Our Ref: P/40/22/NMA

**Section 96A of the Town & Country Planning Act 1990 (as amended)
Town and Country Planning (Development Management Procedure) (England) Order 2015
(as amended) - Article 10**

Non-material amendment following grant of P/70/19/RES to change some brick types on the Materials Schedule to some of the dwelling plots (Plots 51-52, 86-87 and 88-89) and replace rooflights to some plots to dormer windows (Plots 51-52, 86-87 and 88-89).

Land To The West Of Pagham Road Pagham PO21 4NG

Side Elevation

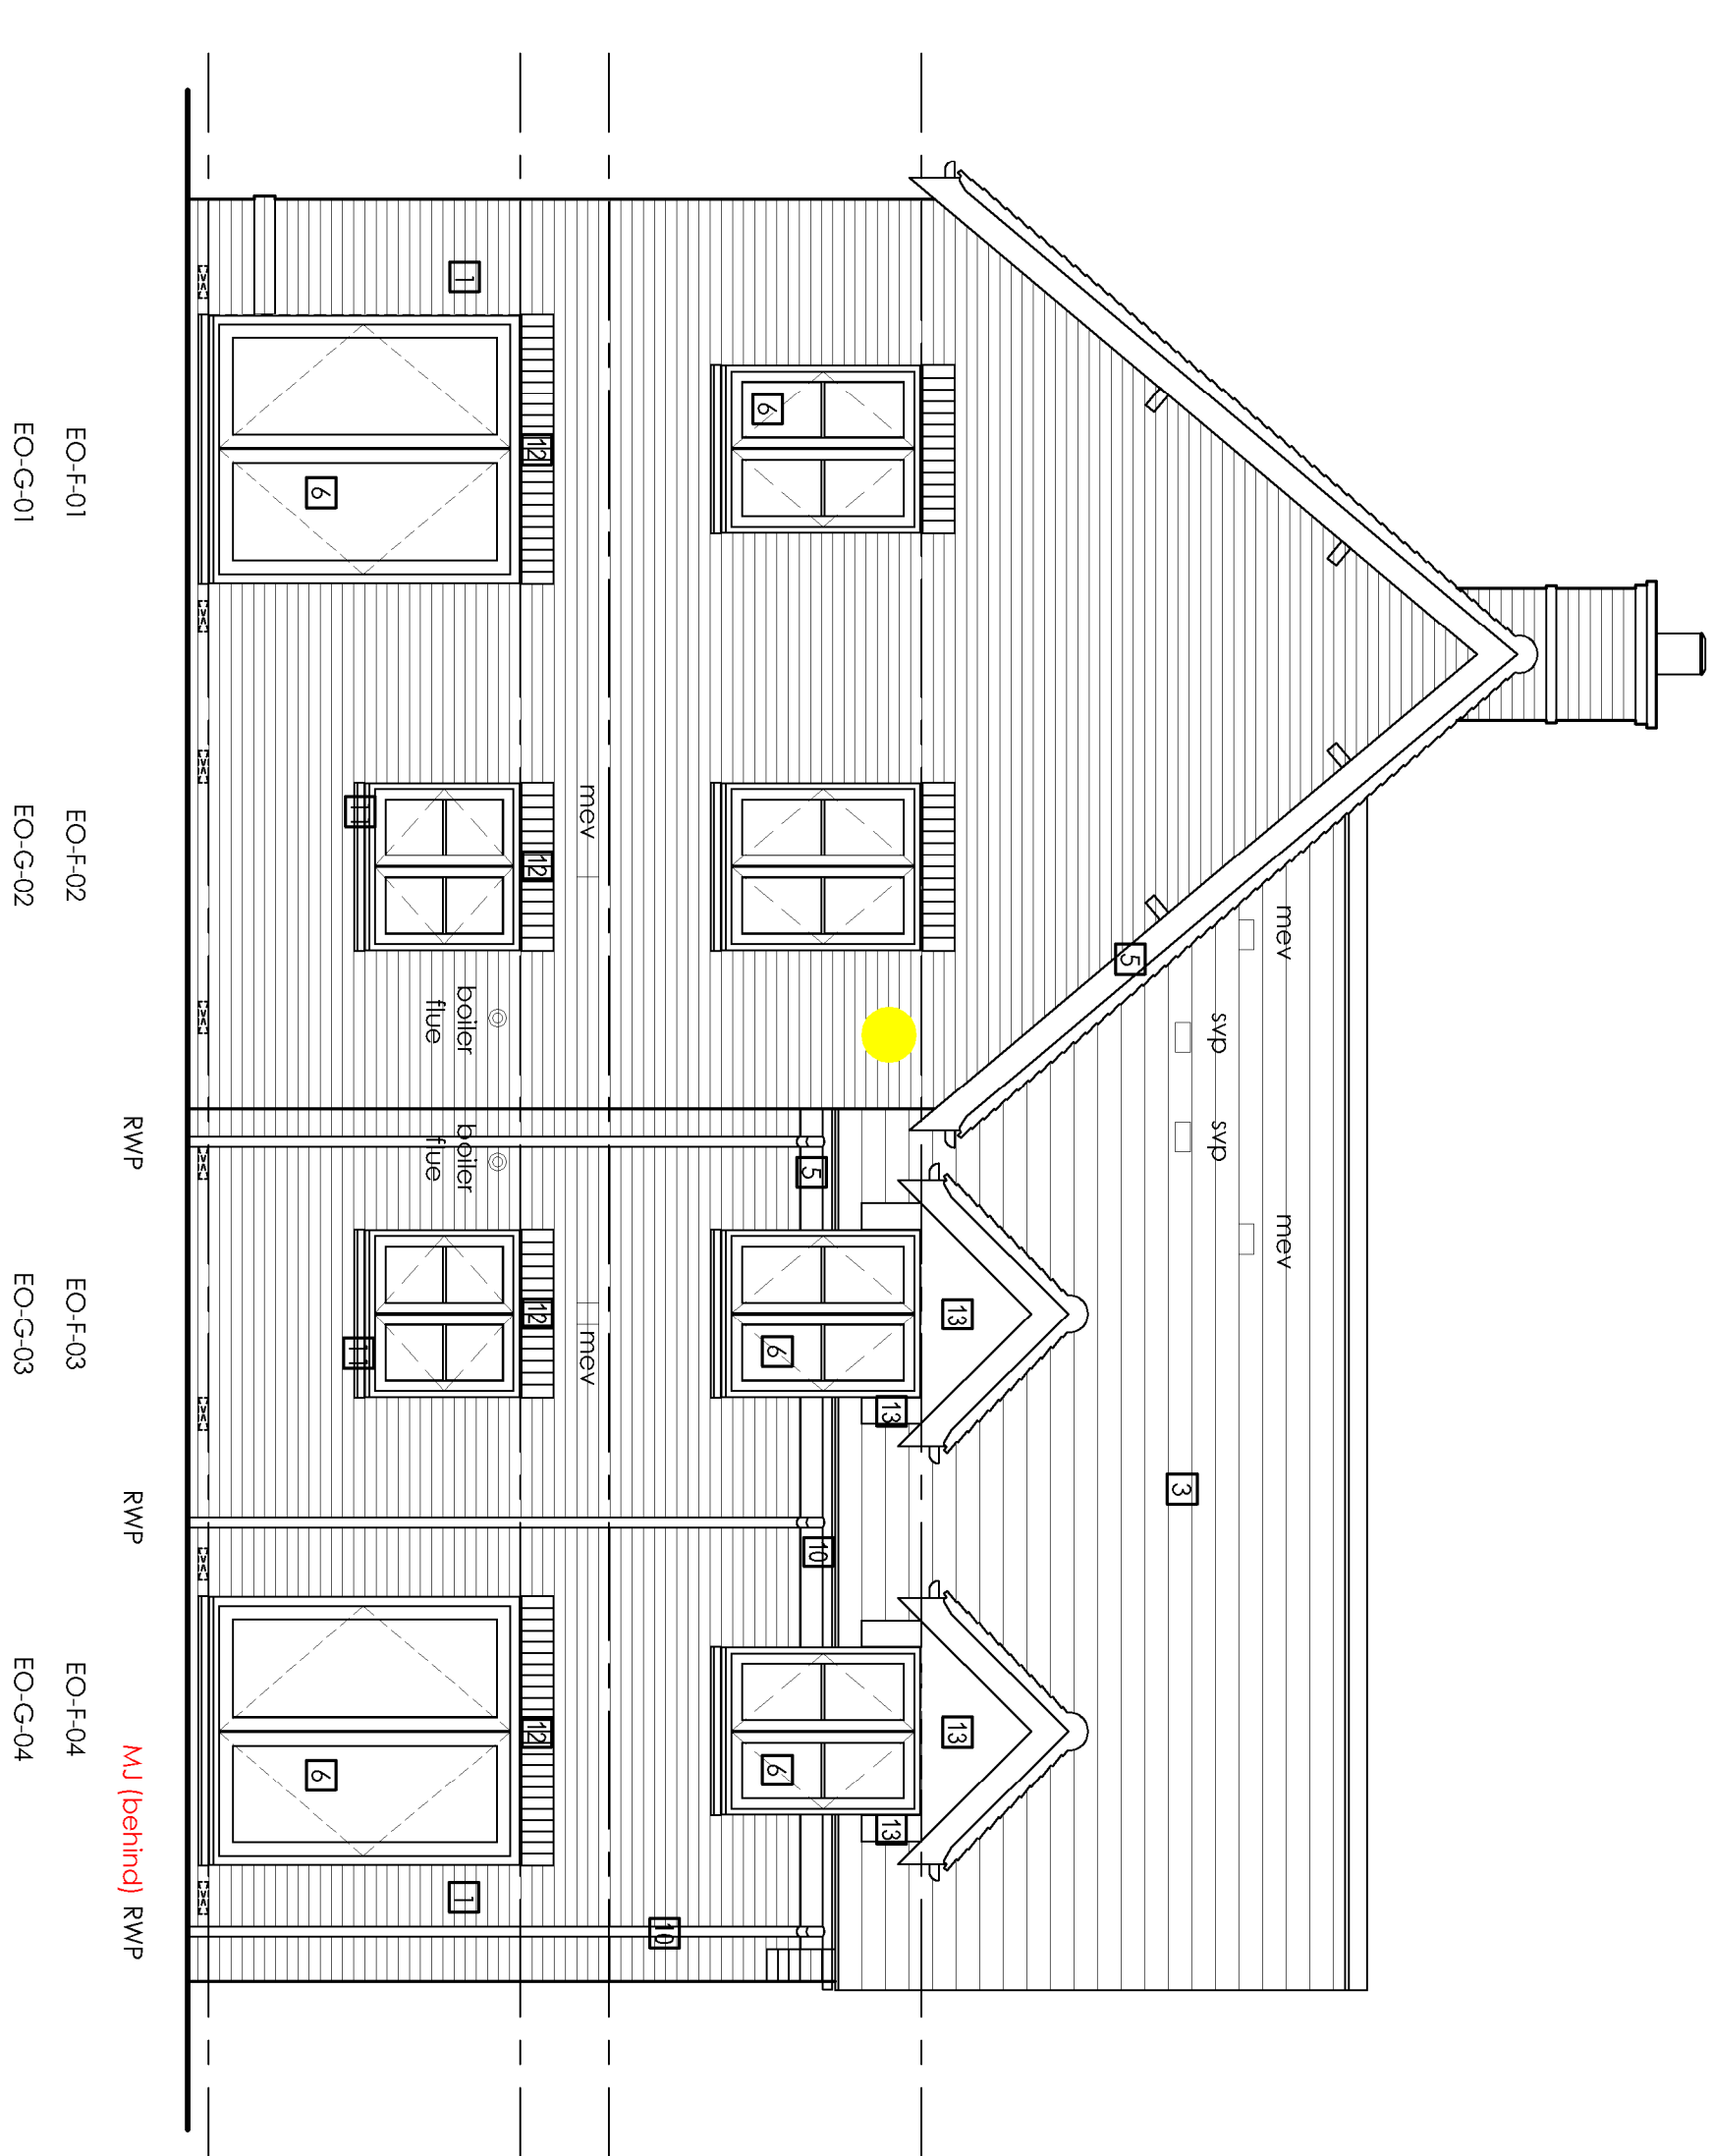
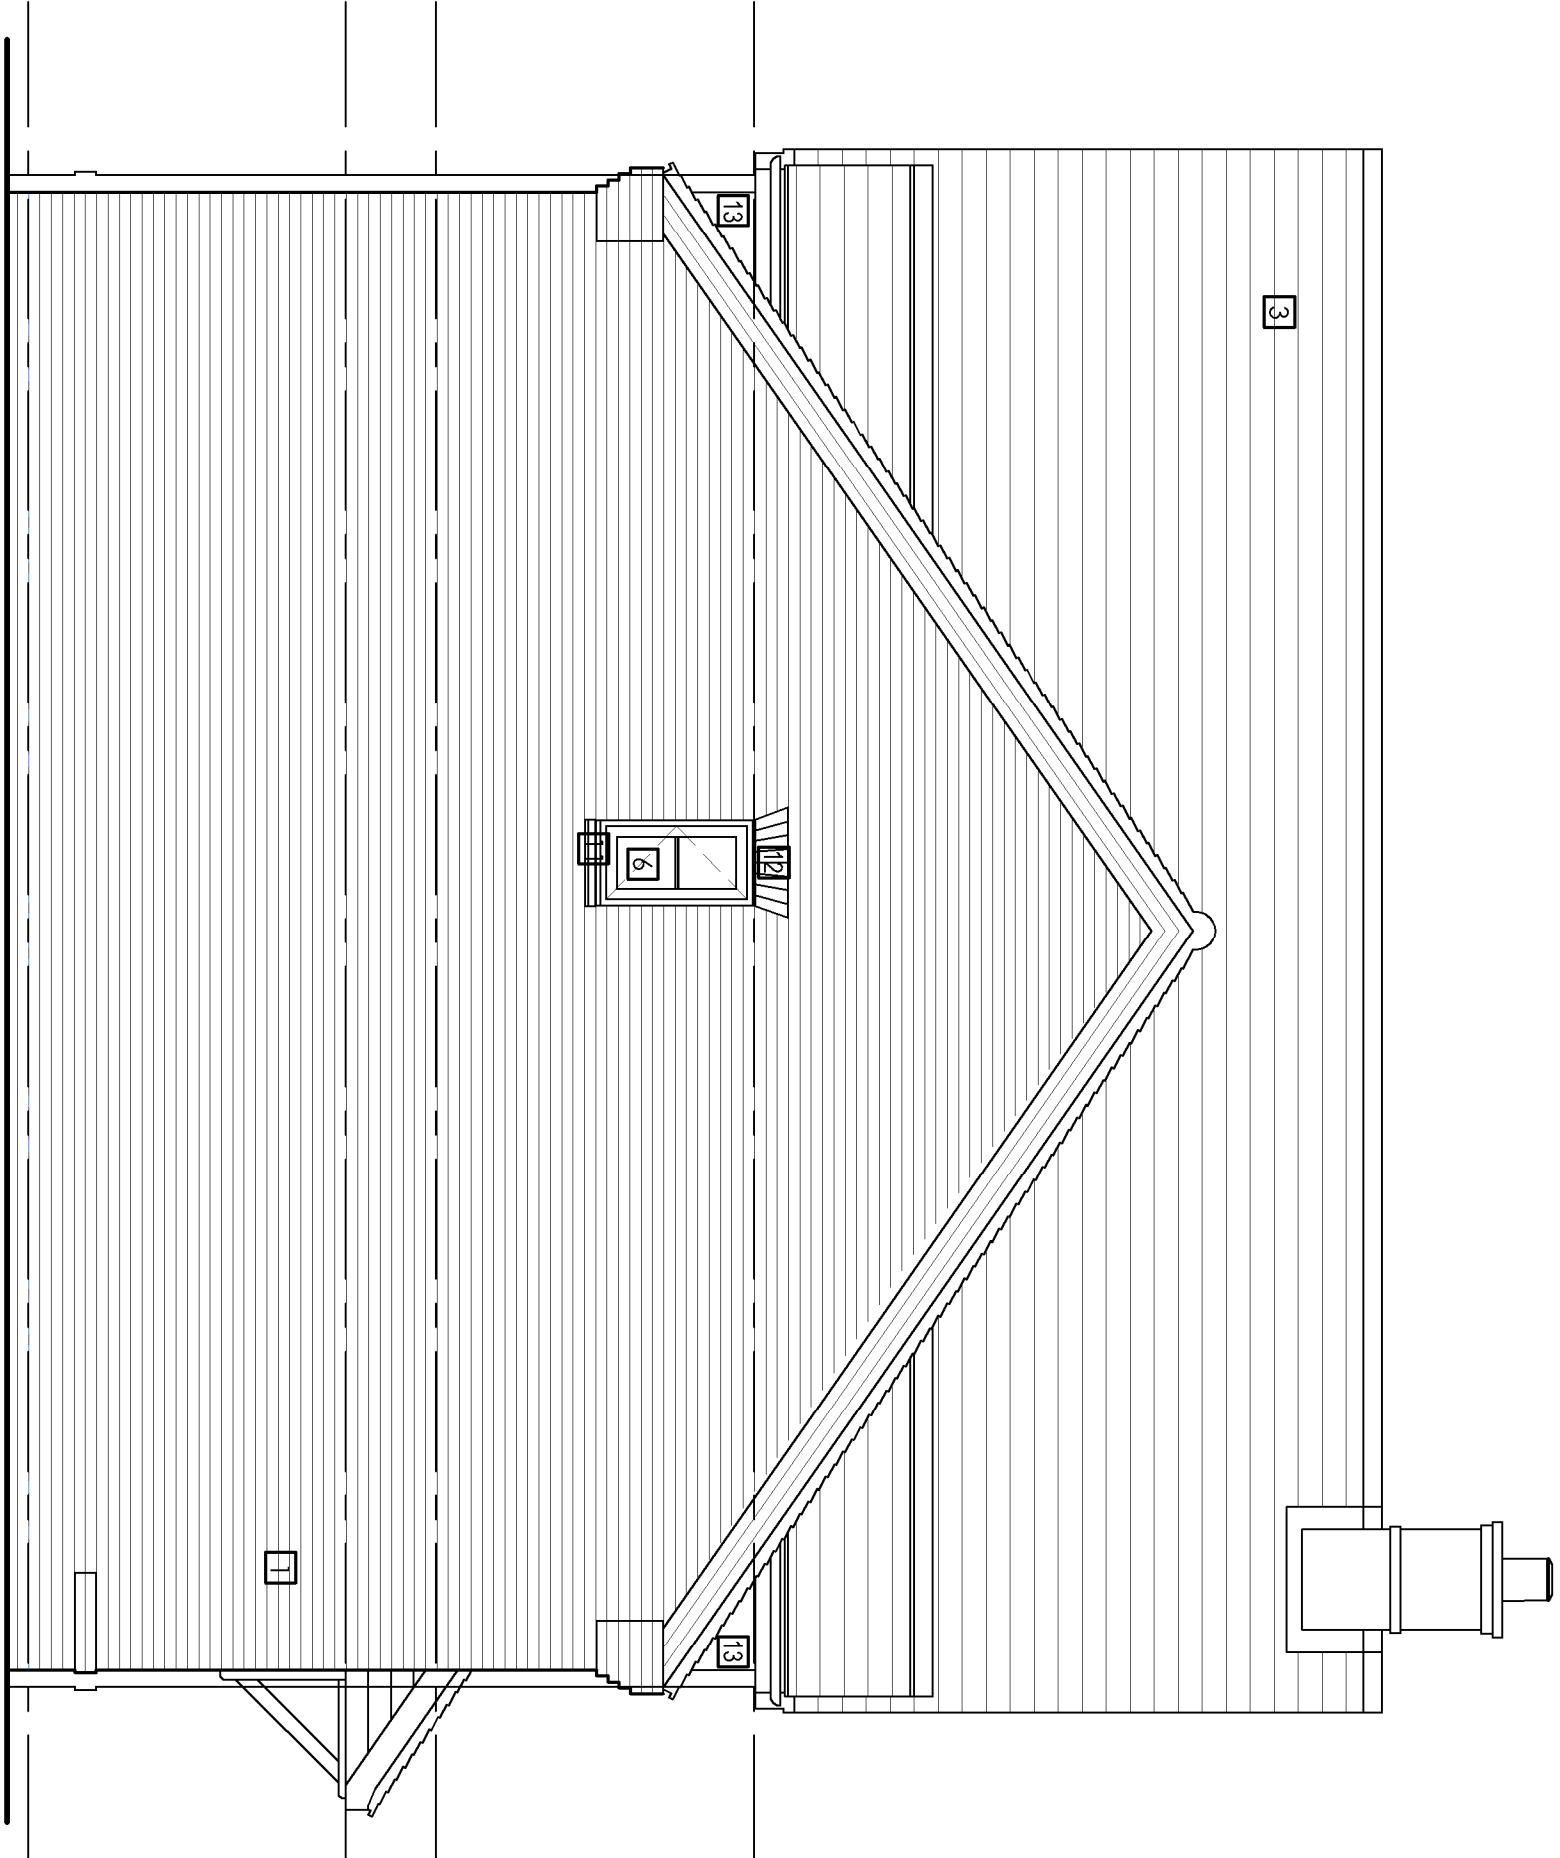
- use Ibstock Thakeham Red Multi Stock to some of the plots;
- use Vandersanden Sundridge Handmade Stock instead to some of the plots;
- replace roof lights on the fronts of the Hickstead house type (plots 51-52 & 86-89 only) with small dormers to match those already on the front and rear elevations.
